Reference No:	2023/62/92833/E
Site Address:	9, Lark Hill, Batley, WF17 0QR
Description:	Erection of first floor extension to side with balcony
Recommending Officer:	Edward Cheseldine

HOUSEHOLDER DELEGATED REPORT

Application Number	2023/92833
Location	9, Lark Hill, Batley, WF17 0QR
Proposal	Erection of first floor extension to side with balcony
Publicity end date	03-Nov-2023
Number of representations received	0
Kirklees Local Plan Allocation/Designation	N/A
Extension to Time (EoT)	No
Recommendation	Conditional Full Permission

PROPOSED SOUTH WEST ELEVATION Scale 1:100

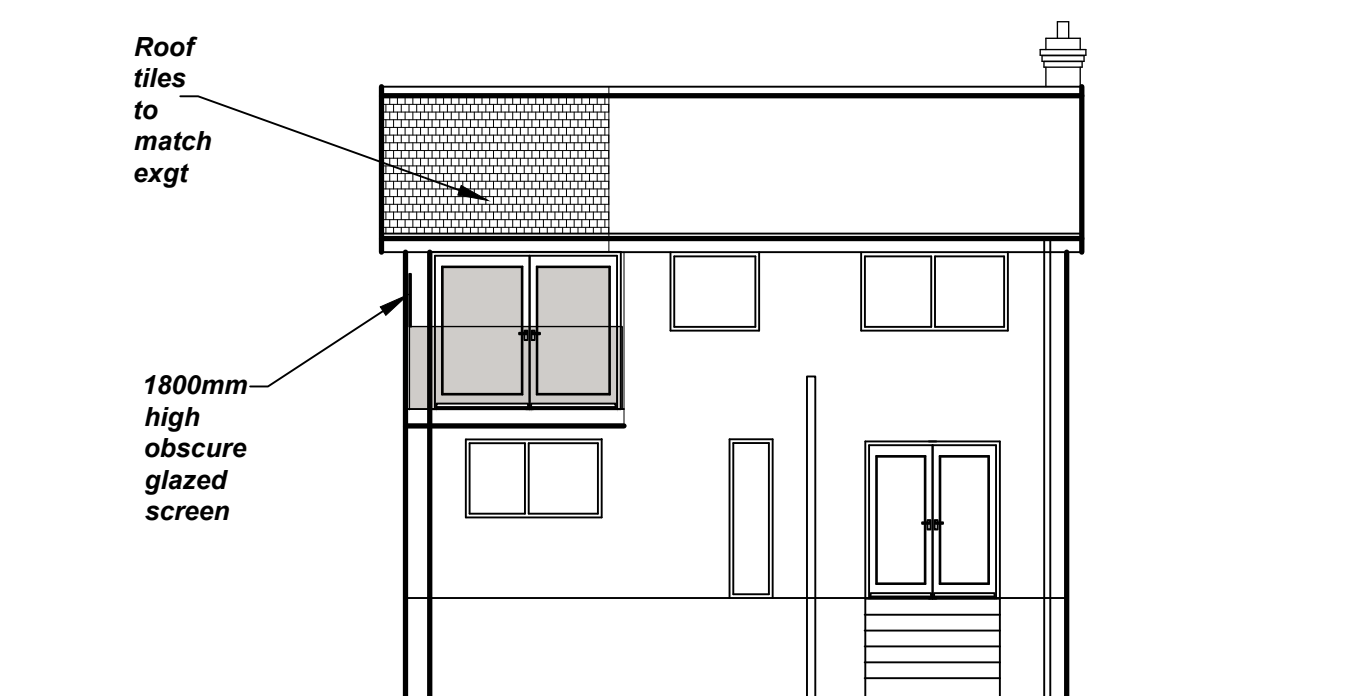
As well as the first-floor extension and the canopy roof, a balcony will be installed on the rear of the property. Balconies can be found on a neighbouring property therefore it is visually acceptable. The balcony will also be assessed in terms of its impact on residential amenity below.

Relevant key design principle (KDP) of the SPD, Policy in the Kirklees Local Plan and the NPPF	Further comments	✓ / X / N/A
Impact on privacy of neighbours (to sides, rear and front)	• KDP 3 & 4 of the SPD • Policy LP24 Design (d) (iv) • Chapter 12 of the NPPF	8 Robin Hill is the property to the west of the application site. The rear boundary of the application site shares its border with the garden of No. 8. The proposal is for a rear facing balcony that has a ~0.70m platform.	✓

In terms of habitable rooms, there are none on the side elevation of No. 8 facing the application property. However, the balcony will be ~10.90m from the rear garden which will be overlooked. In terms of the impact of the construction, the garden of No. 8 is already overlooked due to its residential setting. The additional opening and subsequent balcony will not have an outlook that is not already observed by other windows on the dwelling. Additionally, there is a substantial change in ground height as the land slopes down to the west mitigating the impact of being overlooked. The relationship is therefore acceptable due to distance and ground height.	
Impact on light and outlook of neighbours (to sides, rear and front)	• KDP 4, 5, 6 of the SPD • Policy LP24 Design (b) • Chapter 12 of the NPPF	Due to distance the balcony will not result in a loss of light out outlook to neighbours.	✓

4. The development shall not be occupied until a 1.8m obscurely glazed screen (to a minimum Grade 4) has been placed on the north-west elevation of the balcony. Notwithstanding the provisions of the Town and Country Planning (General Permitted Development) Order 2015 as amended (or any Order revoking or re-enacting that Order) the obscure glazing (to a Grade 4) shall thereafter be retained.

PROPOSED NORTH WEST ELEVATION Scale 1:100

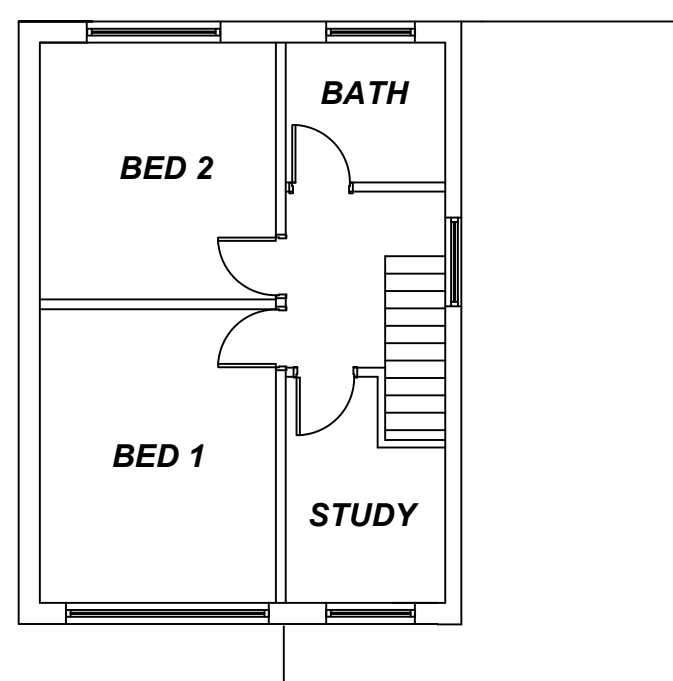
Impact on privacy of neighbours (to sides, rear and front)	• KDP 3 & 4 of the SPD • Policy LP24 Design (d) (iv) • Chapter 12 of the NPPF	11 Lark Hill is to the north-west of the application site and is the adjacent property. There are no side windows which will face this property therefore there will be no impact to privacy. The proposed balcony will have an obscured screen 1.8m on the north-west face.	✓
Impact on light and outlook of neighbours (to sides, rear and front)	• KDP 4, 5, 6 of the SPD • Policy LP24 Design (b) • Chapter 12 of the NPPF	The extension will form a close first-floor elevation to the neighbour, being ~1.30m from the property boundary. The application site does not project forward or rearward of the No.11. Additionally, the closest side elevation of No.11 is a two-storey wall with no windows. Because of this, there will not be a loss of light or a loss of outlook.	✓

PROPOSED FIRST FLOOR PLAN Scale 1:100

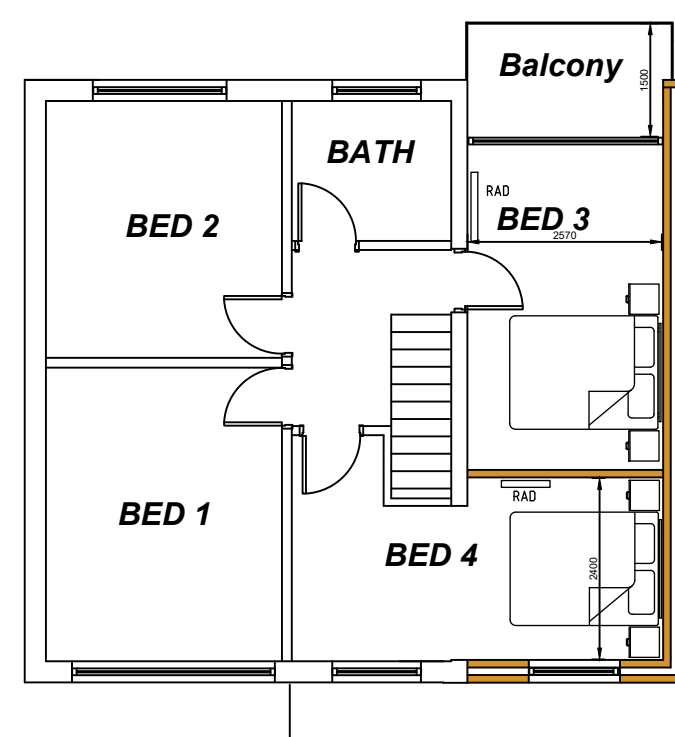
<u>Yes - COMPLY</u>	<u>No - JUSTIFY</u>
Ideally be visually smaller in relation to the original house;	Yes. The side extension is ~2.70m in width on a ~6.00m dwelling, with an existing garage underneath.	
Be set back at least 500mm from the front of the original house to provide a vertical break from the roof plane and for the lowering of the ridgeline from the original house;		No. The first-floor side extension will occupy an 'infill area' where there is a gap in the development above the garage space. The design will create a uniform first-floor elevation. There will be the appearance that this elevation is set back from the canopy roof and the forward projection of the garage. Given there is a visual break from the canopy projection the continuity of the ridgeline is acceptable.
Have a roof design that follows the form of the existing roof; and	Yes. the pitched roof design is retained within the design of the extension.

Retain a gap of at least 1 metre to boundary walls to avoid a terracing effect and to retain rear access to gardens.	Yes. A ~1.35m gap will be retained from the extension to the boundary gap.	
--	--	--

Relevant key design principle (KDP) of the SPD, Policy in the Kirklees Local Plan and the NPPF	Further comments	✓ / X / N/A
Impact on the Local character and street scene	• KDP1 of the SPD • Policy LP24 Design (a) and (c) of the KLP • Chapter 12 NPPF	The extension and canopy will form commonplace, residential features that will not appear out of place given the character of the street. The majority of houses have canopies on the ground floor and triple windows on the first-floor. Neither will the dwelling appear large given there are wider properties on the road.	✓
Impact on original house	• KDP2 of the SPD	The extension will not appear disproportionately large to the original house	✓
